LSC Responses to TIS Redline Comments

Sterling Ranch Sketch Plan 2023 Amendment & Rezone Traffic Technical Memorandum (LSC #S224441) September 28, 2023

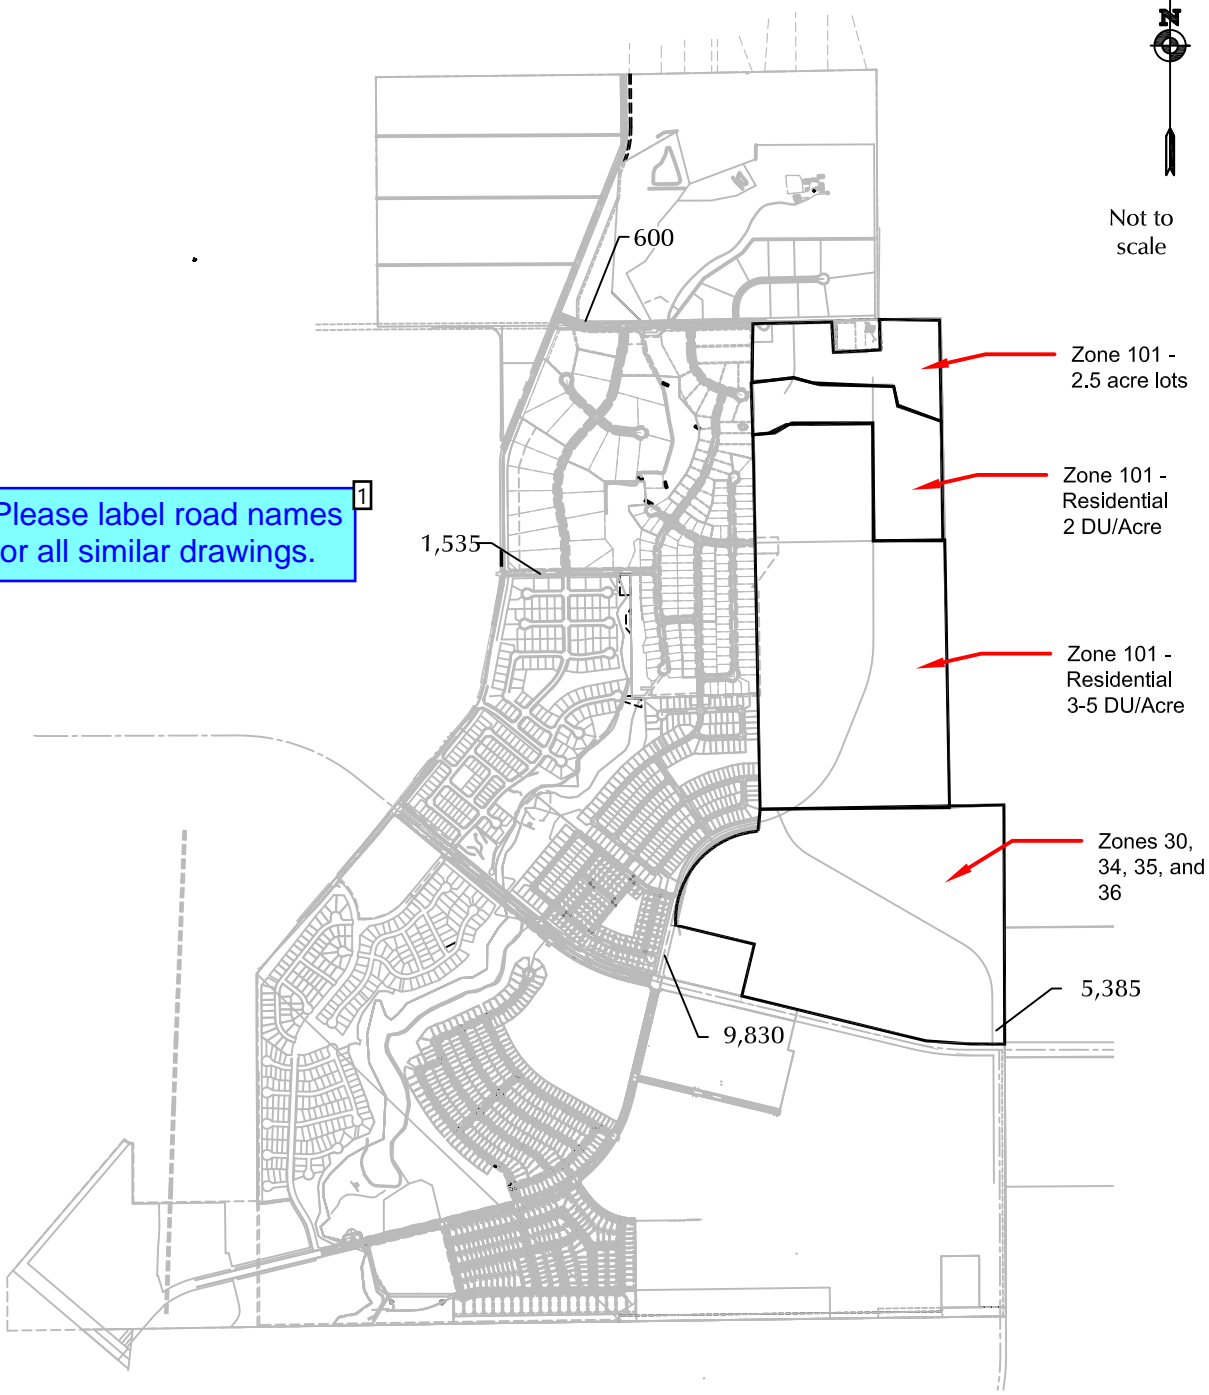
Address how Sterling Ranch Road will be connected to Arroya Lane and the anticipated classification of Arroya, and with the additional density in this area how this increases the possibility of the ultimate east-west connection of Arroya Lane along the north side of Sterling Ranch (if the property to the north subdivides).

Address how Sterling Ranch Road will be connected to Arroya Lane and the anticipated classification of Arroya, and with the additional density in this area how this increases the possibility of the ultimate east-west connection of Arroya Lane along the north side of Sterling Ranch (if the property to the north subdivides).

3. show connection on all figures

show connection on all figures

Author: kdferrin Subject: Sticky Note Date: 12/15/2023 9:37:39 AM
LSC Response: The additional information has been added as requested.

LSC Response: The figures have been updated as requested.

Figure 6

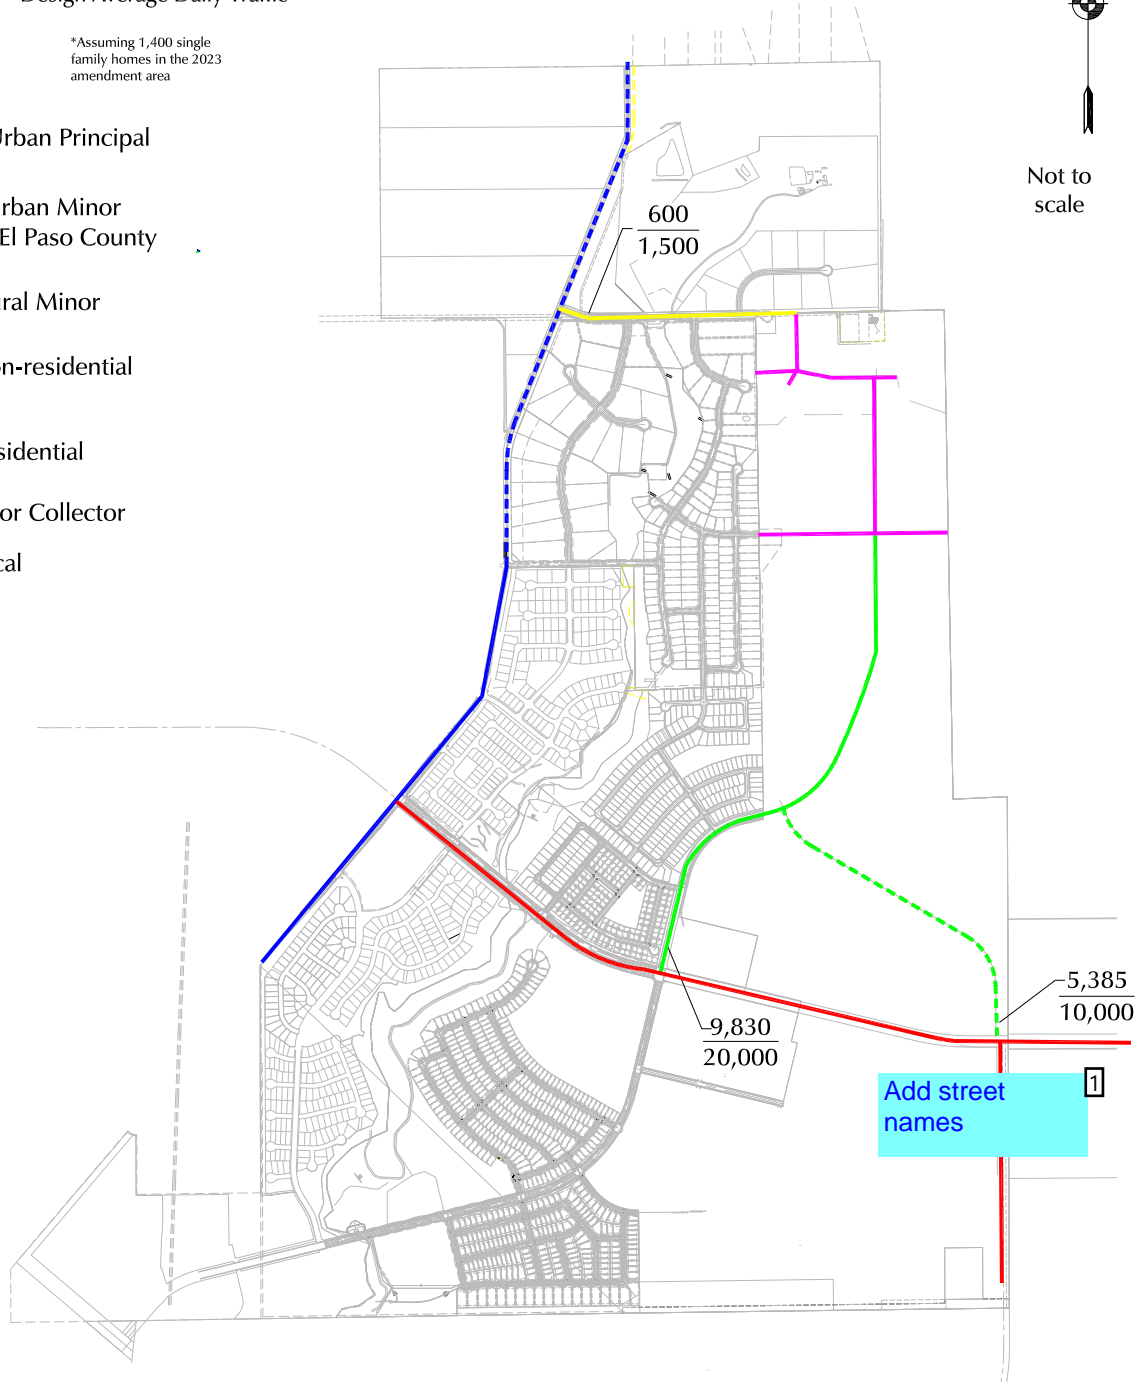
[show connection](#)

Author: kdferrin Subject: Sticky Note Date: 12/15/2023 9:38:10 AM
LSC Response: The figures have been updated as requested.
